30 June 2025

Re: Formal Objection to SSD-82548708 – Proposed Residential Flat Building with Infill Affordable Housing at 24, 26 and 28 Middle Harbour Road, Lindfield

Drawing Name
Level 04 Setback

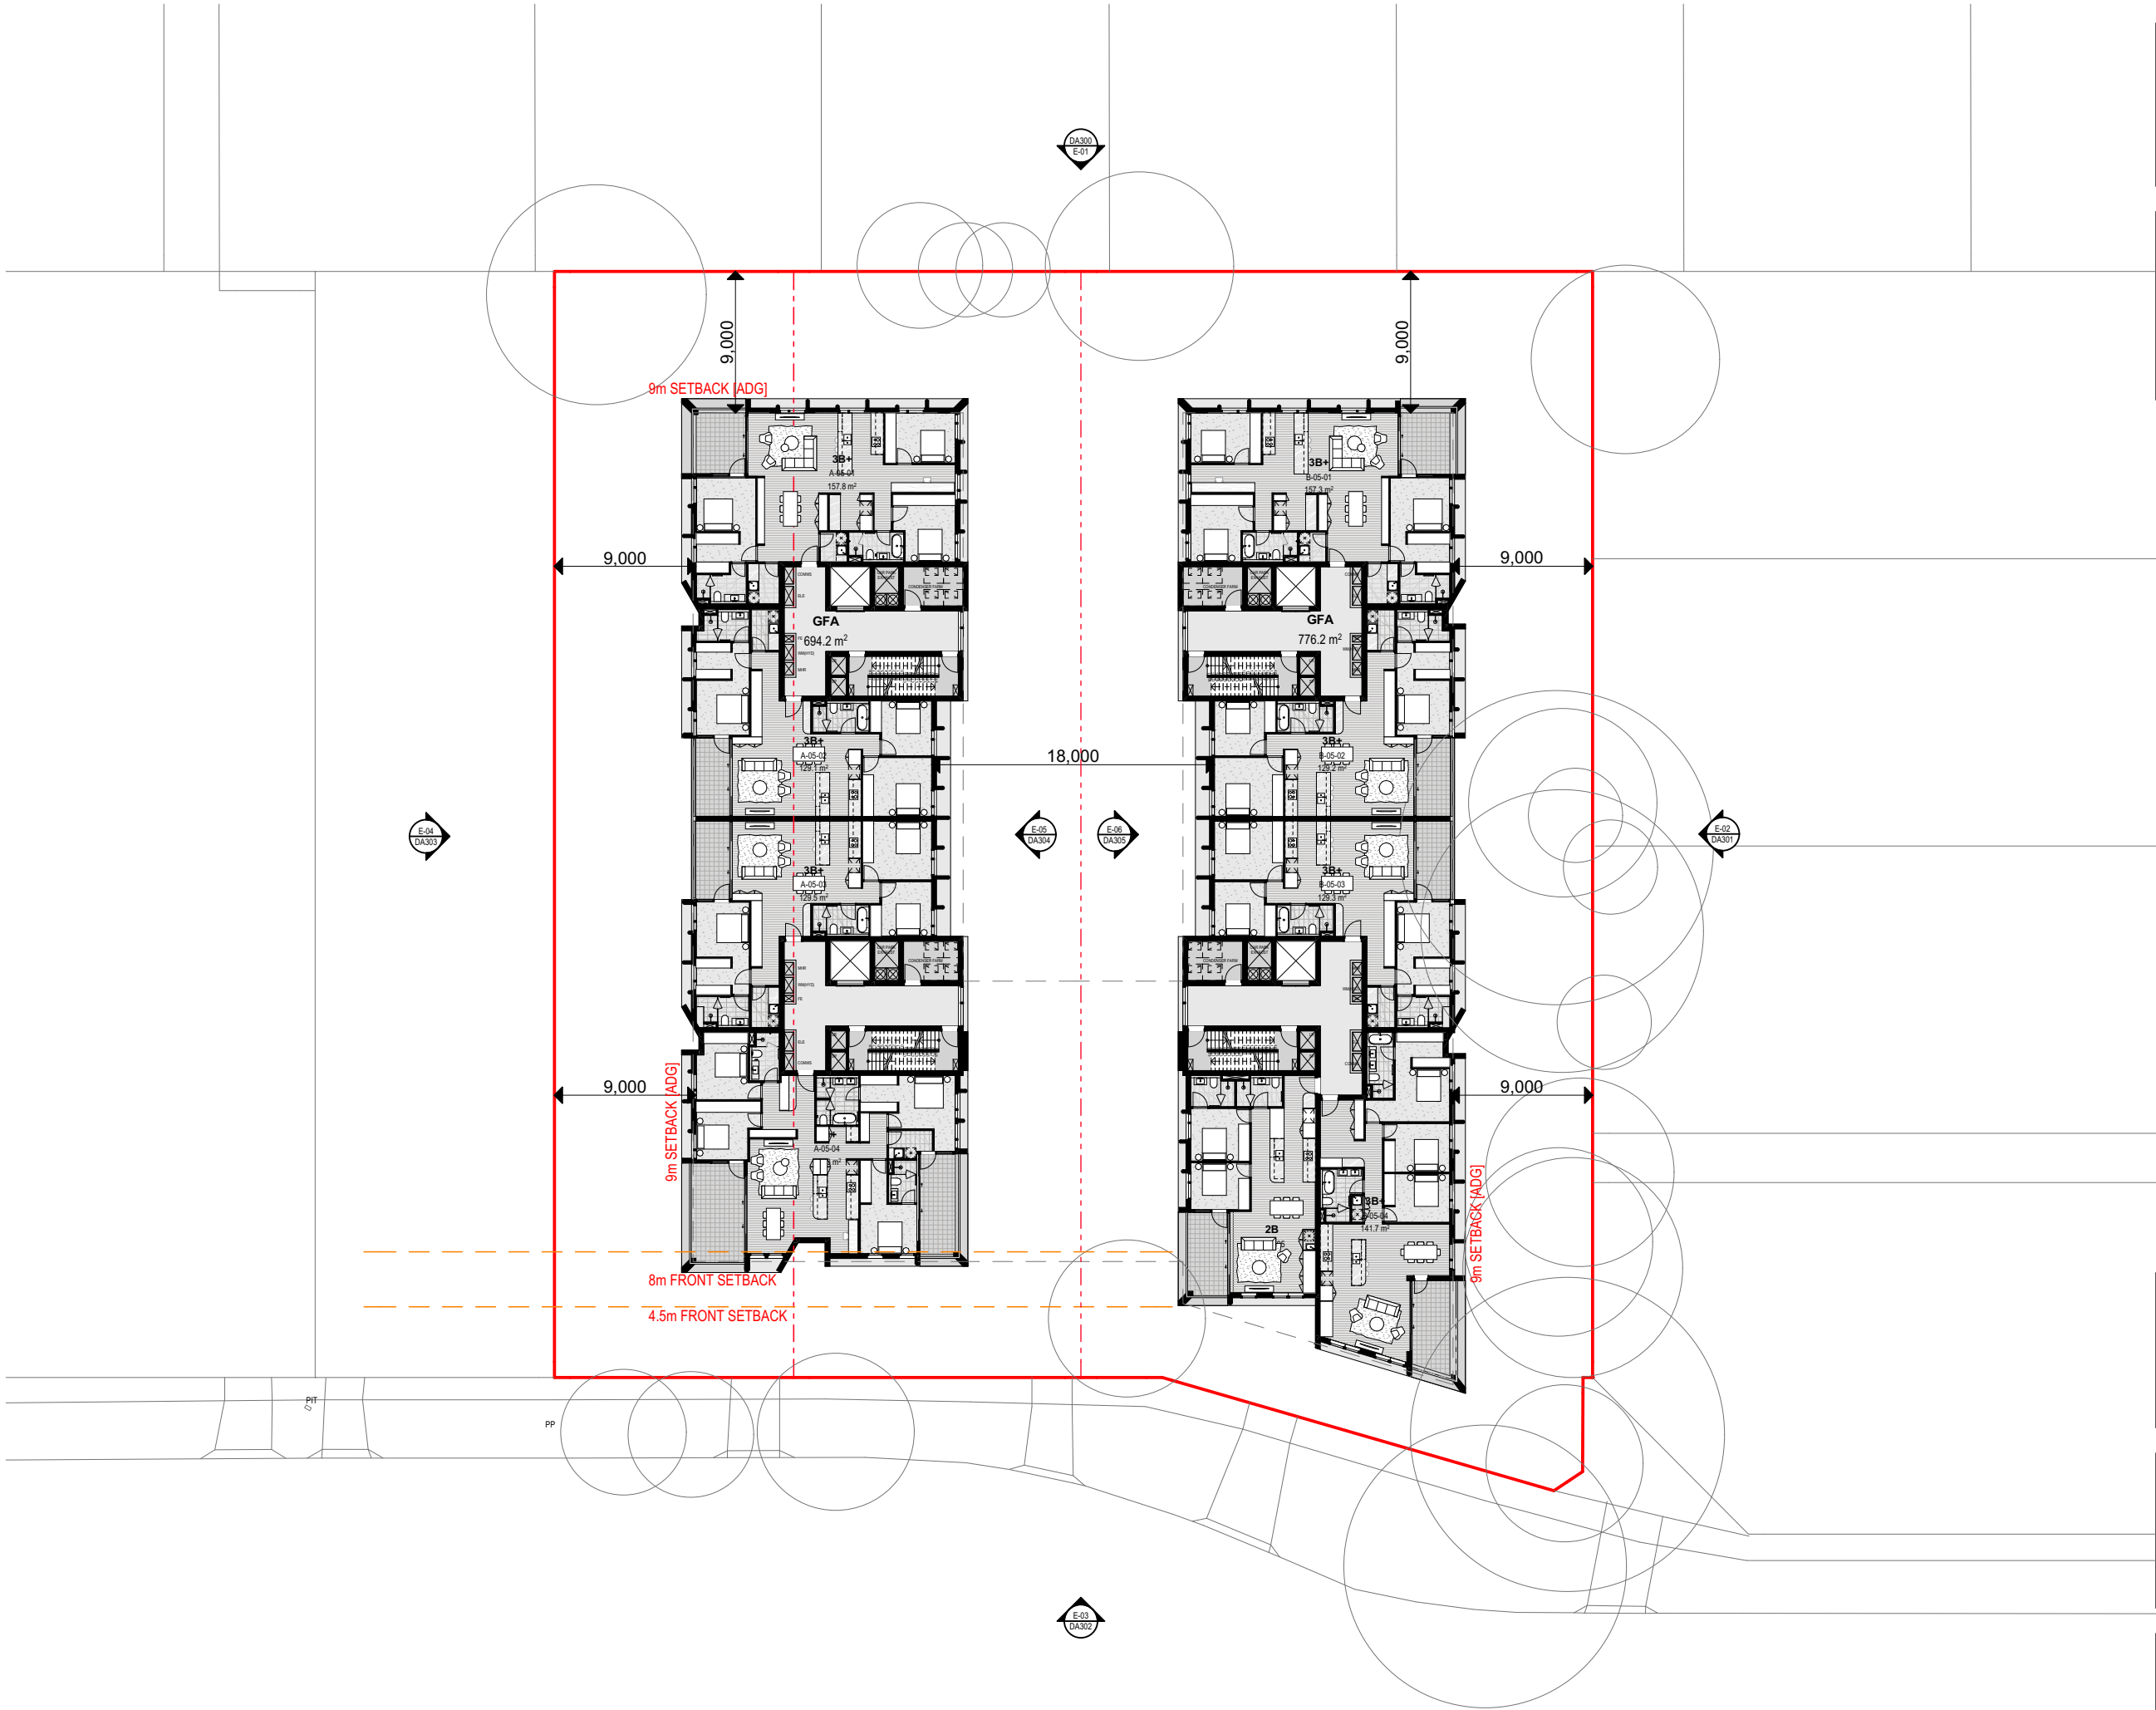
- The proposed development **fails to comply** with the **Apartment Design Guide (ADG)** requirements for separation distances from existing low-density homes.
- Setbacks from **eastern boundary properties on Trafalgar Avenue** are inadequate:
 - **Lower Ground Floor terraces** are less than 4 metres from the shared fence line (ADG requires **minimum 8 metres**).
 - **No. 22 Middle Harbour Road** is just 2 metres from the western shared boundary—**grossly insufficient**.
 - **No. 19 Russell Avenue (a listed Heritage Item)** warrants a **minimum 12-metre setback**.
- These substandard setbacks result in **privacy breaches, overshadowing, and unacceptable visual intrusion** into adjacent low-scale dwellings.

Drawing Name
Deep Soil Diagrams

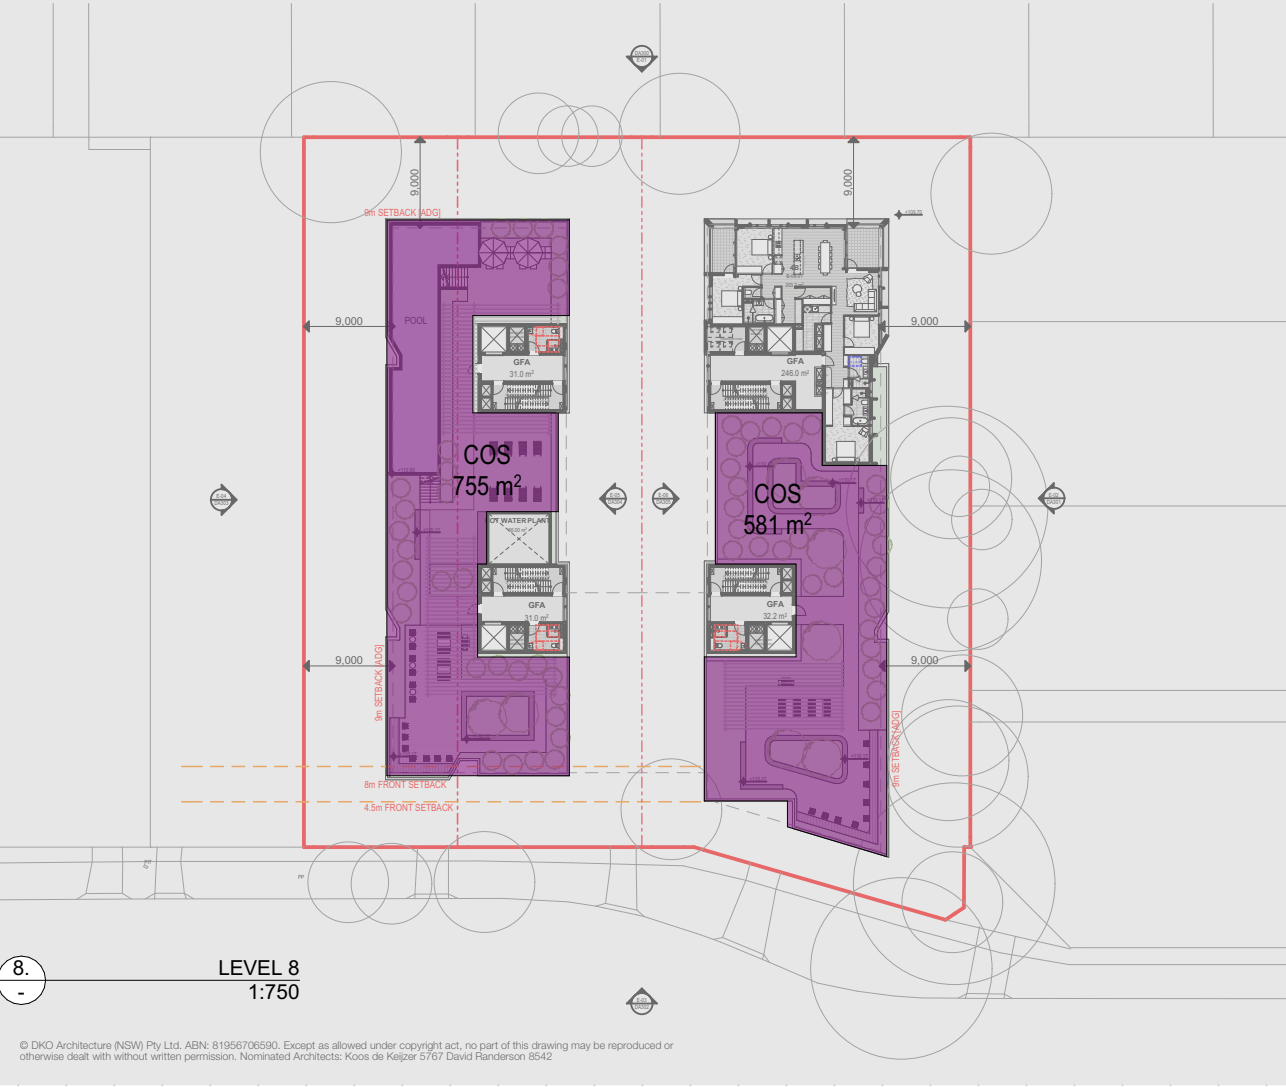
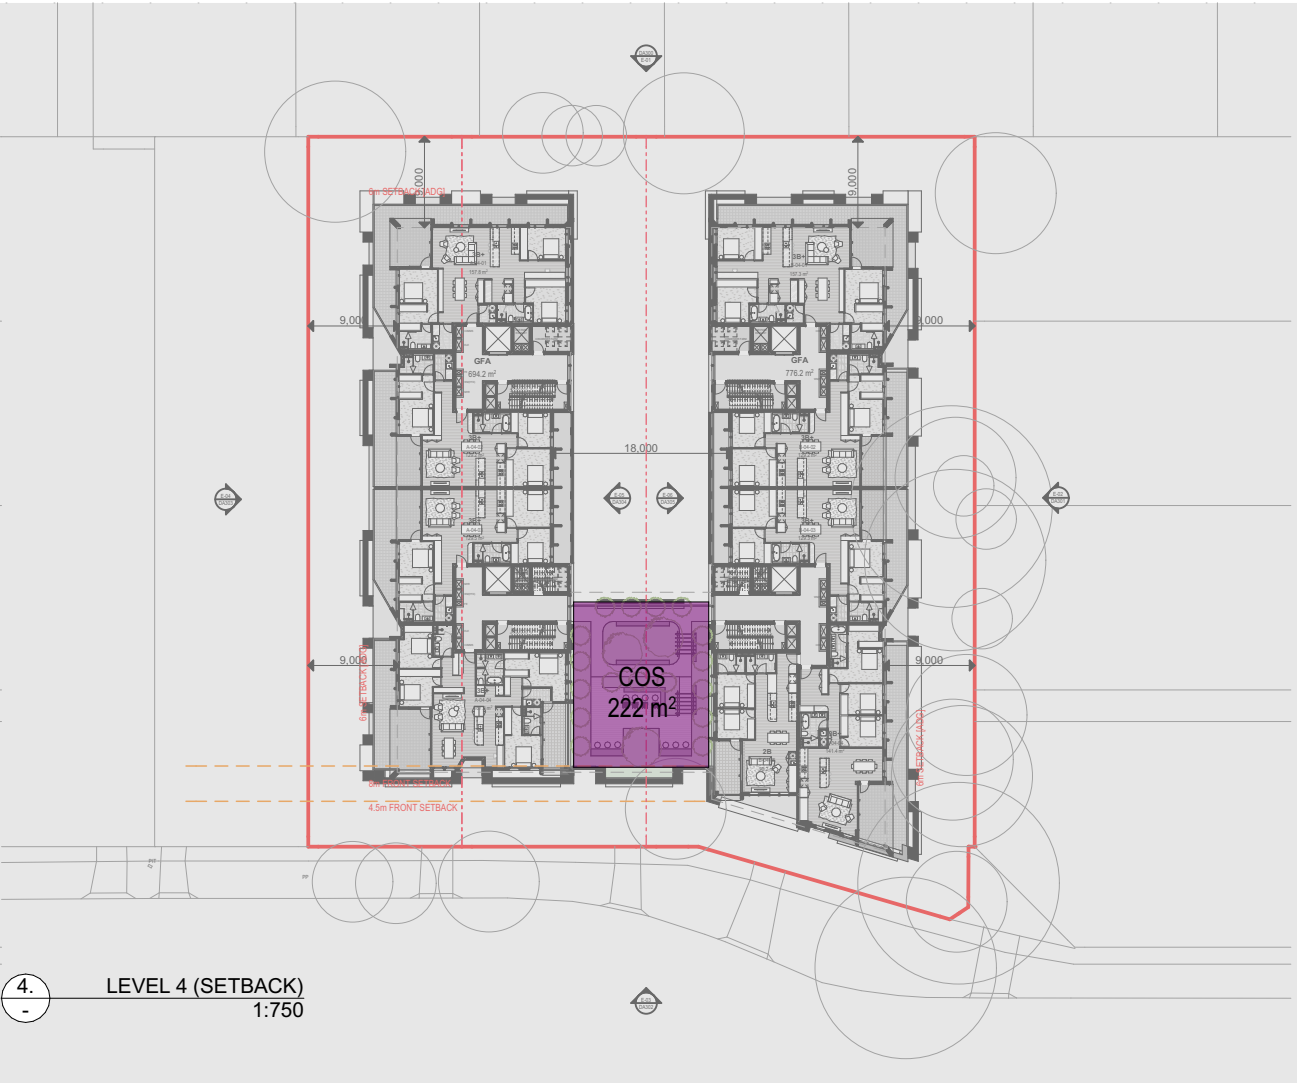
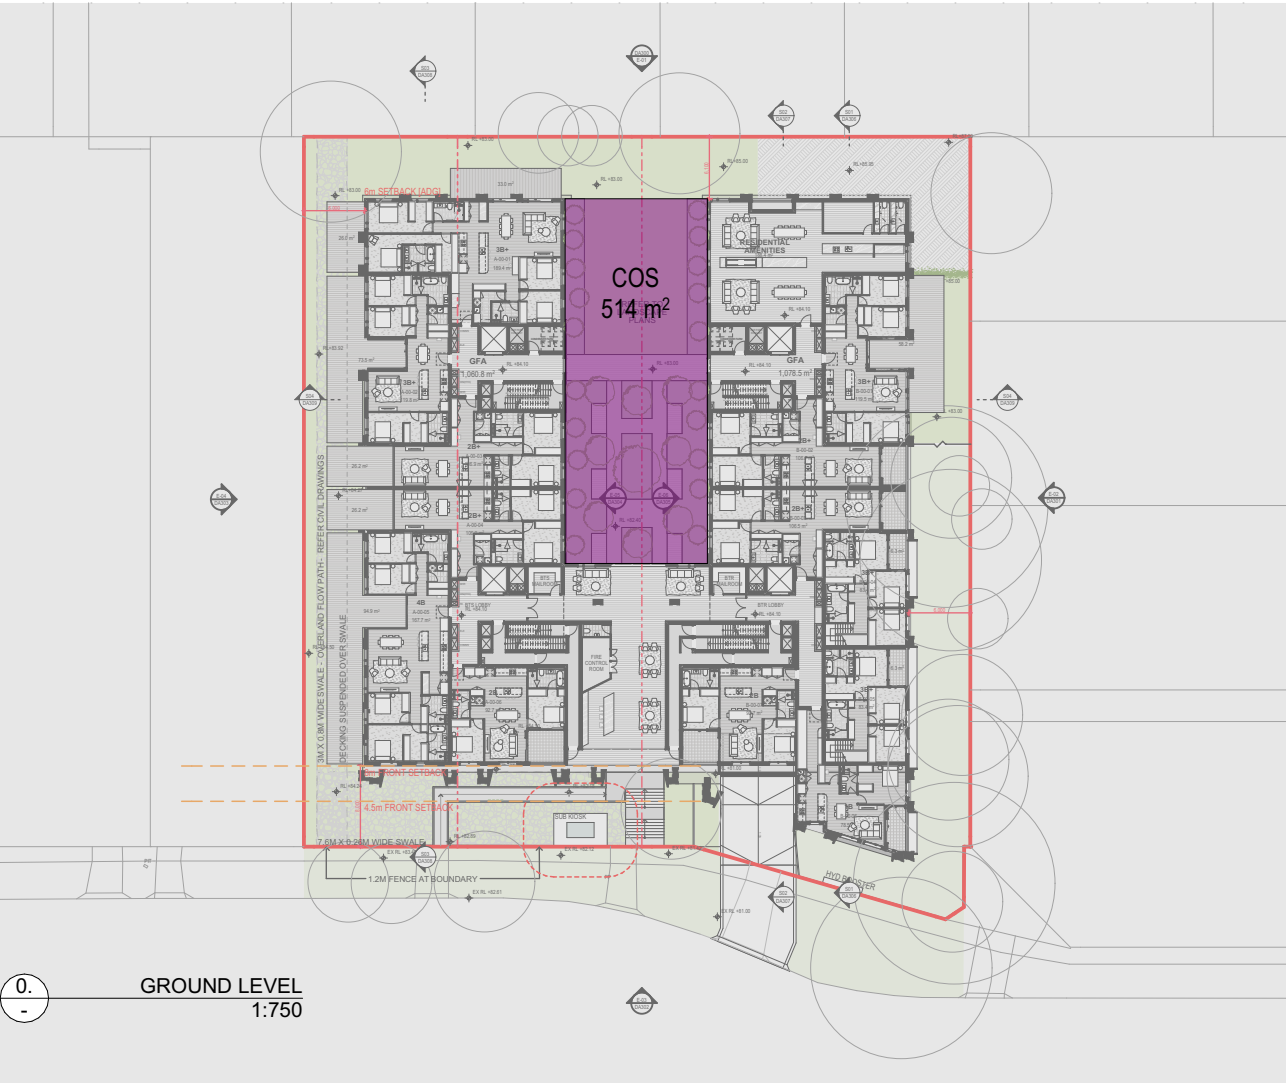
- Deep soil coverage is only **27.8%**, well below the **50% minimum** required by Council.
- This figure is **further overstated**, as the **western basement parking structure extends beyond the building footprint**, violating deep soil zone principles.
- Landscaping over structures **cannot** be considered valid deep soil planting.
